5 October 2018

Our Reference: SYD18/00547/02
DP&E Ref: SSD9241

**CAMPBELLTOWN HOSPITAL REDEVELOPMENT STAGE 2
TERRY ROAD, CAMPBELLTOWN**

1 PLAN - PROPOSED ROADWORK - MAIN ENTRY
1 : 1000

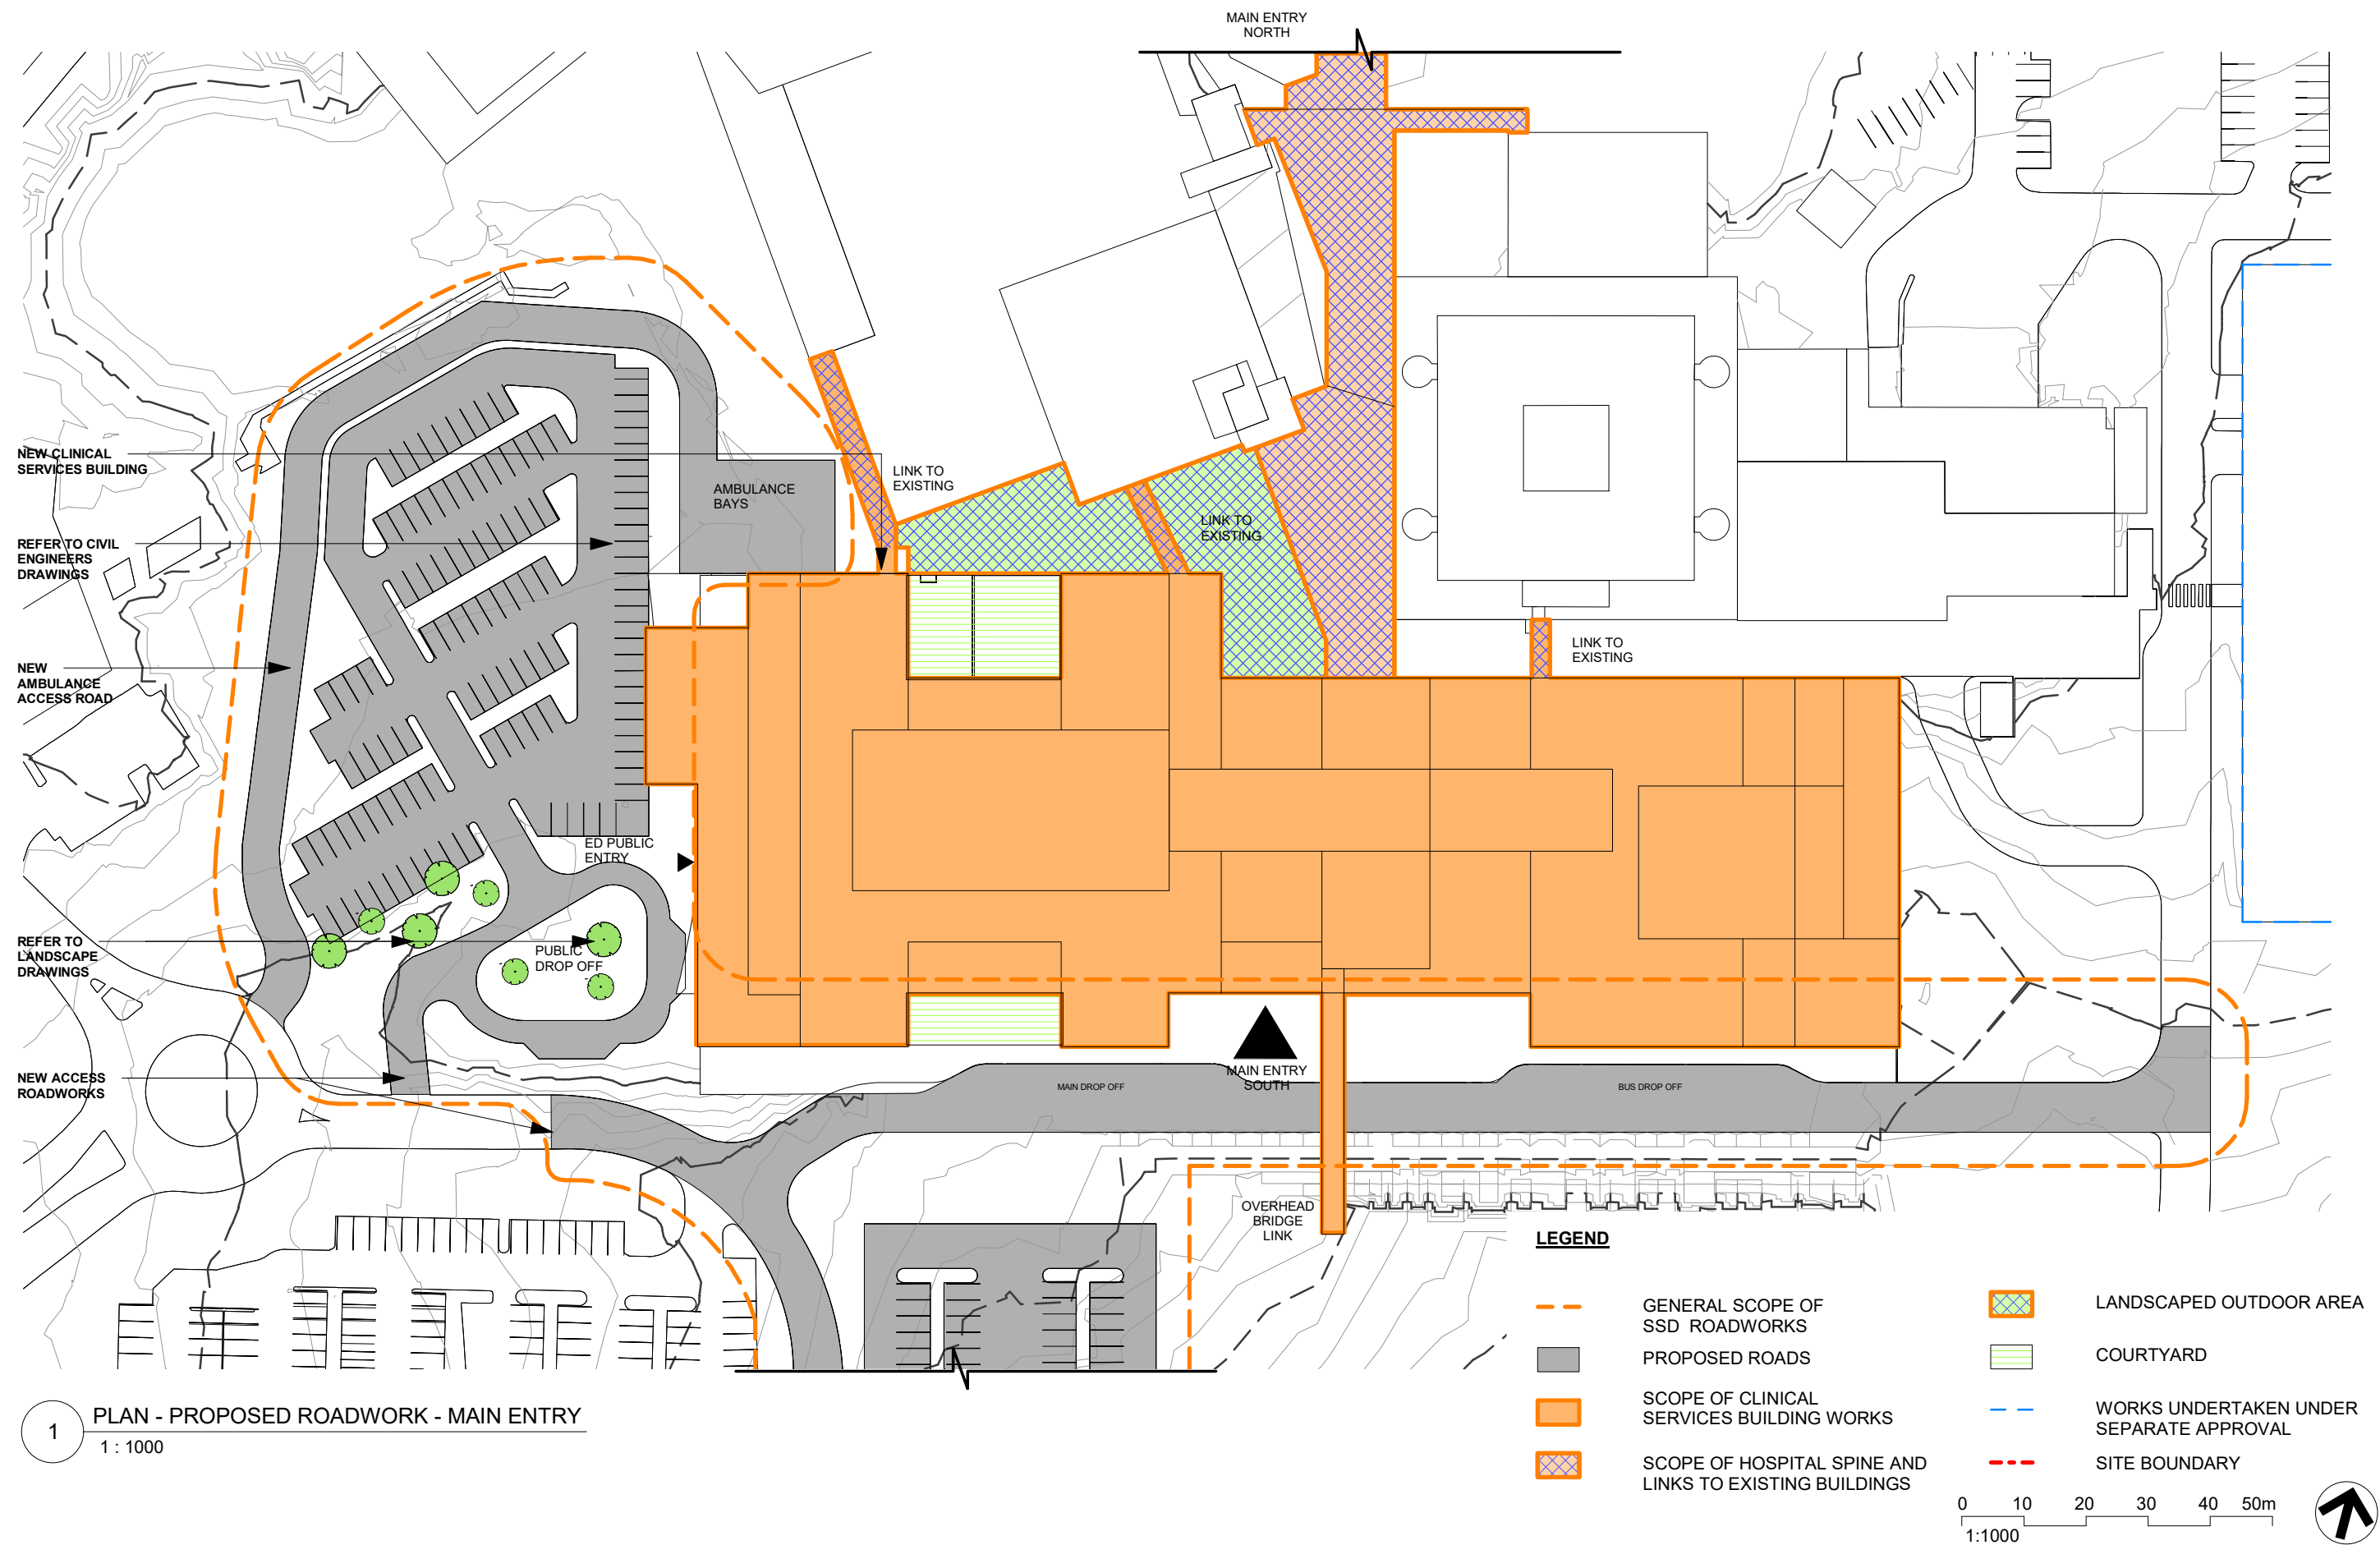
1. Roads and Maritime does not support the proposed acceleration lane on Appin Road and requires a high-angle exit.
2. The required deceleration lane on Appin Road shall be designed to meet Roads and Maritime's requirements, and endorsed by a suitably qualified practitioner. The design requirements shall be in accordance with AUSTRROADS and other Australian Codes of Practice. The certified copies of the civil design plans shall be submitted to Roads and Maritime for consideration and approval prior to the release of the Construction Certificate and commencement of road works.

3. Swept path plans to be provided for the largest vehicles accessing the site on Appin Road for review. The access should cater for the simultaneous entry/exit of vehicles. If the access is used for construction access, additional turning path should be provided for the largest construction vehicles accessing the site
